## About the application

Application number: 2025/92713	
What is the application for?:	Reserved matters application pursuant to outline permission 2023/92079 for erect
Address of the site or building:	Rear of, 23 to 43, Moor Lane, Gomersal, Cleckheaton, BD19 4LF
Postcode:	LS10 1NB

## User comments

2539 - D - 20 - 016

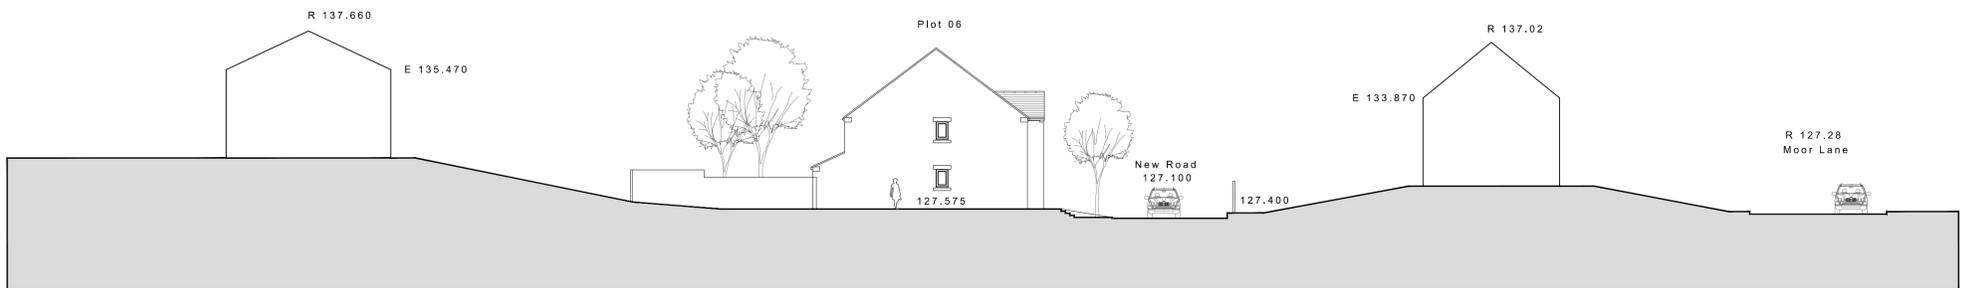
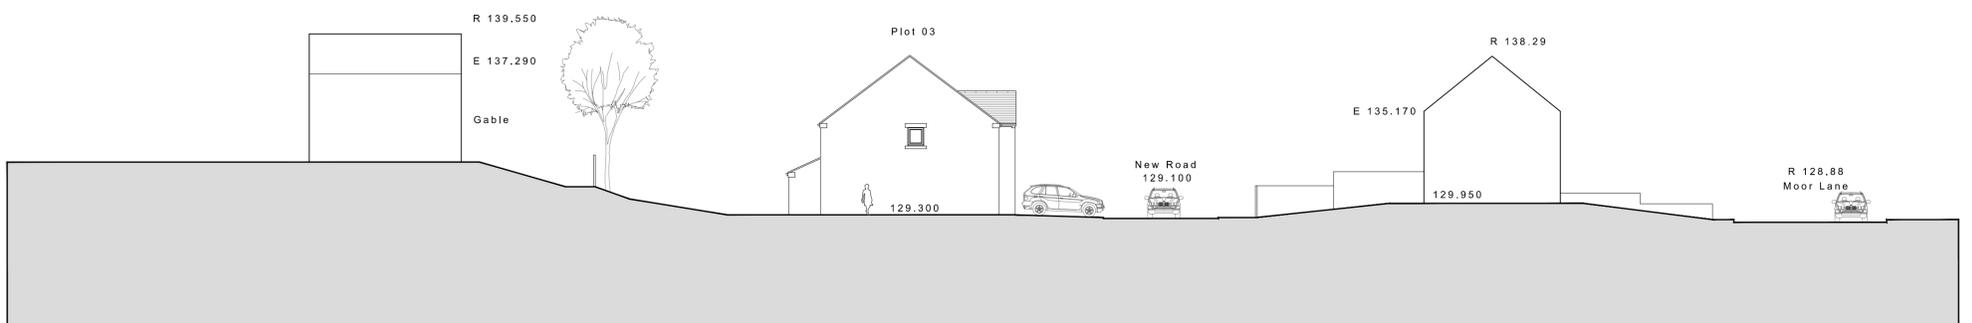
Similarly the 5 Bedroom House on plot 10 at the bottom end of the site will be only 2.00 to 4.00 metres from the boundary of No 21 Summerdale. It would have a floor level approximately 2.00 metres higher and a ridge height some 3.80 metres higher than 21 Summerdale. This will seriously affect their privacy and daylight.

Drawing Number: 2539-D-20-002 - H
 Revision: -
 Do not scale from this drawing. Work to original dimensions, and any discrepancy to be reported to the AHJArch.
 Refer to larger scale drawings where available.

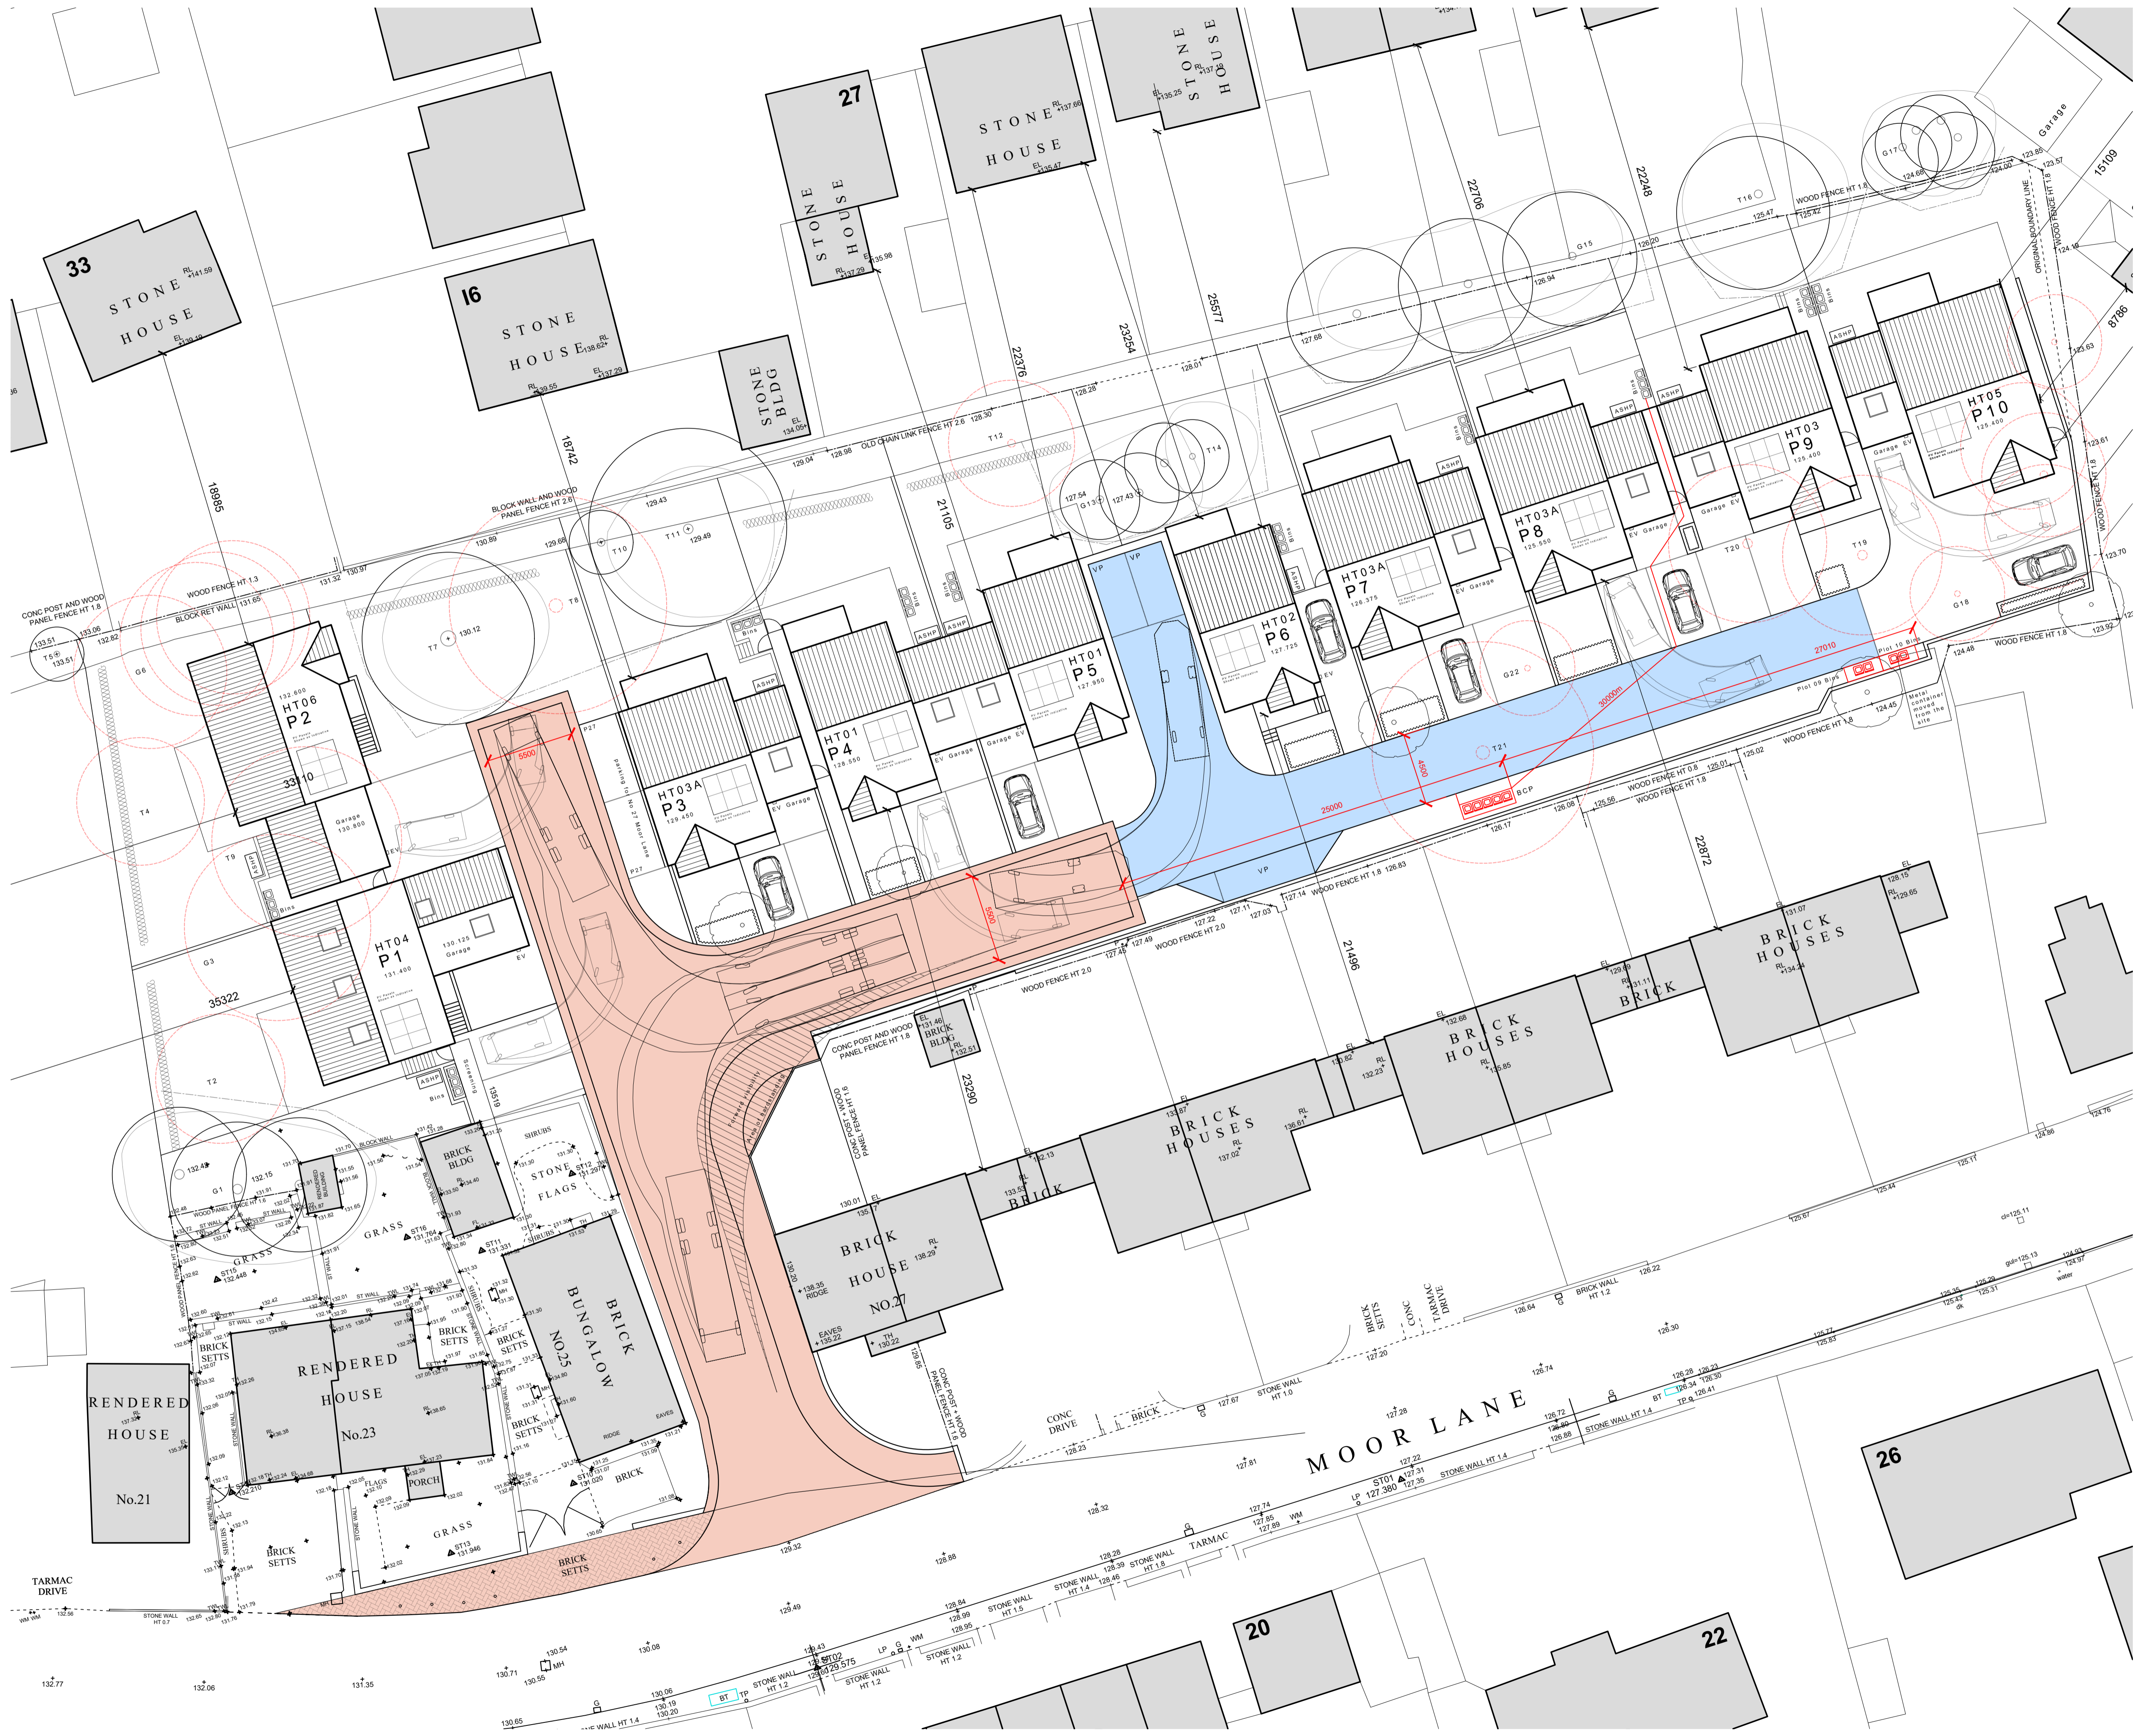
Surprisingly the 5 Bed House on plot 1 is actually 3 storey as the roof height has been increased to allow the roof space to be used for additional accommodation, despite a previous condition that all properties must be 2 storey.

Also as this house is at the entrance to the site and at the highest point on the development it would have more of a detrimental impact on the existing properties.

As the majority of properties are larger than the original granted outline permission, these cover a larger footprint, meaning that the overall density has increased. The result is the houses being much closer to one another, with only a narrow 1.00 metre wide footpath separating all but one of them, despite an earlier condition that properties must be at least 2.00 metres apart.

Also, 2 of the properties are linked by garages to each other.

This has clearly reduced garden size along with less areas for grass and planting, and the two "Communal Grassed Zones" have disappeared.

The Bin storage areas and waste collection points appear not to comply with legislation . This has been commented on by KC Waste Strategy ( Refuse & Recycling) who state "the maximum drag out distance from bin storage area to BCP ( Bin Collection Point ) is 25m ( BS 5906)".

On checking this it appears that Plot 7 " Drag Distance " only just complies with this requirement, but plots 8, 9 & 10 exceed the permitted distance. Plot 8 has a drag distance of 30metres, Plot 9, 43metres, and plot 10 has over 65metres approximately.
